From: Breezie Allwright on behalf of Planning.Responses
Sent: 02 December 2025 11:39
To: Planning Scanning
Subject: FW: Planning Application Number: BR/200/25/HH

I am writing to formally object to the planning application for a double garage and home office at 186 Aldwick Road (Application Number: BR/200/25/HH).

Block Plan

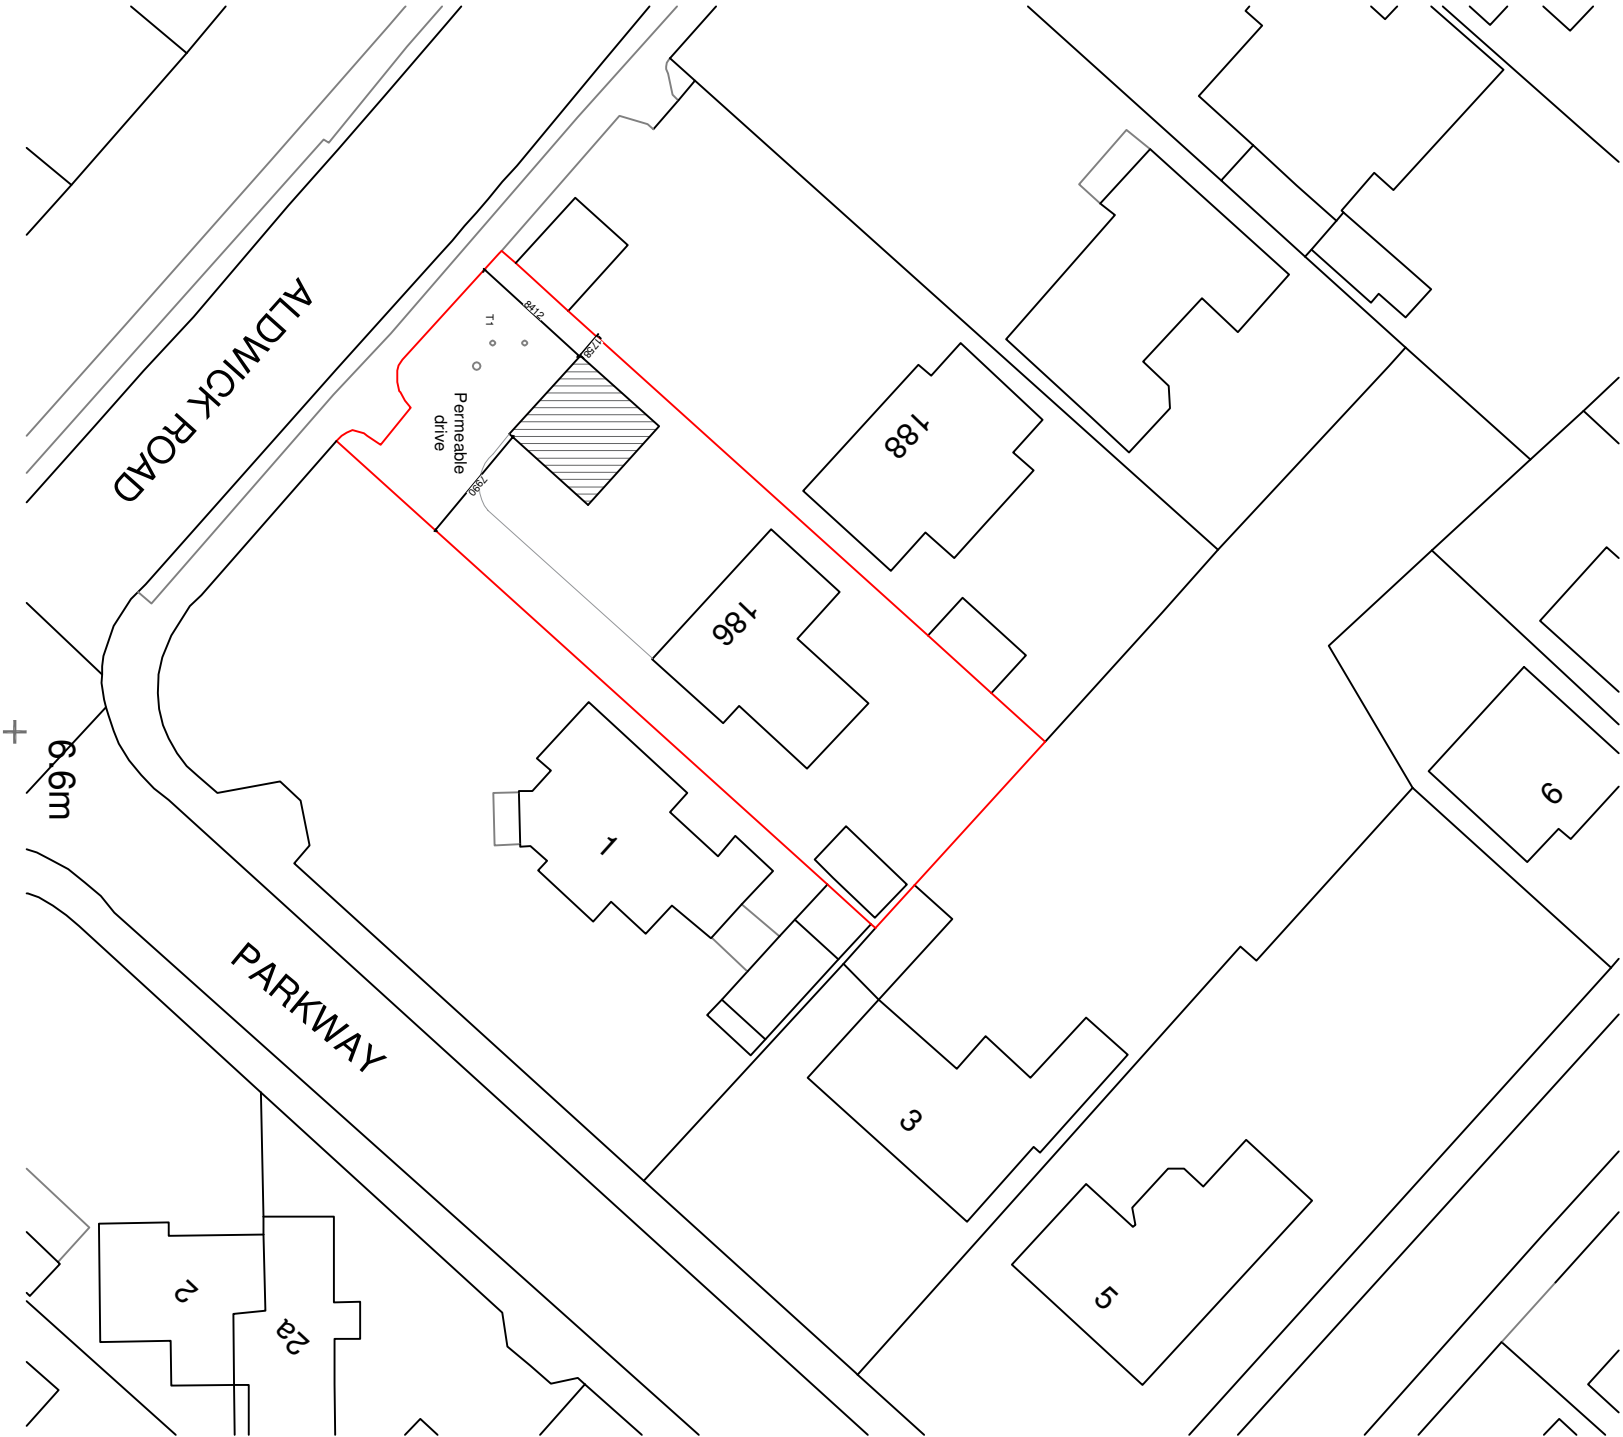
Any new development should respect local character and contribute positively to the streetscape. The proposed garage and office, positioned in front of the property, are significantly oversized and highly visible—out of keeping with Aldwick Road’s character of open frontages and properties set well back from the street.

The addition of a large hard-surfaced driveway—tight for manoeuvring and parking into two garage spaces—would intensify activity and diminish the area’s tranquillity, undermining the peaceful residential nature that residents value. **Based on the submitted plans, I do not believe there is sufficient space to safely turn and park vehicles within the site, which could result in vehicles reversing onto Aldwick Road, increasing highway safety concerns.**

The proposed oversized garage and office at the front of the existing house and garage encroaches on the established building line, disrupting the rhythm of properties set back with open front gardens.
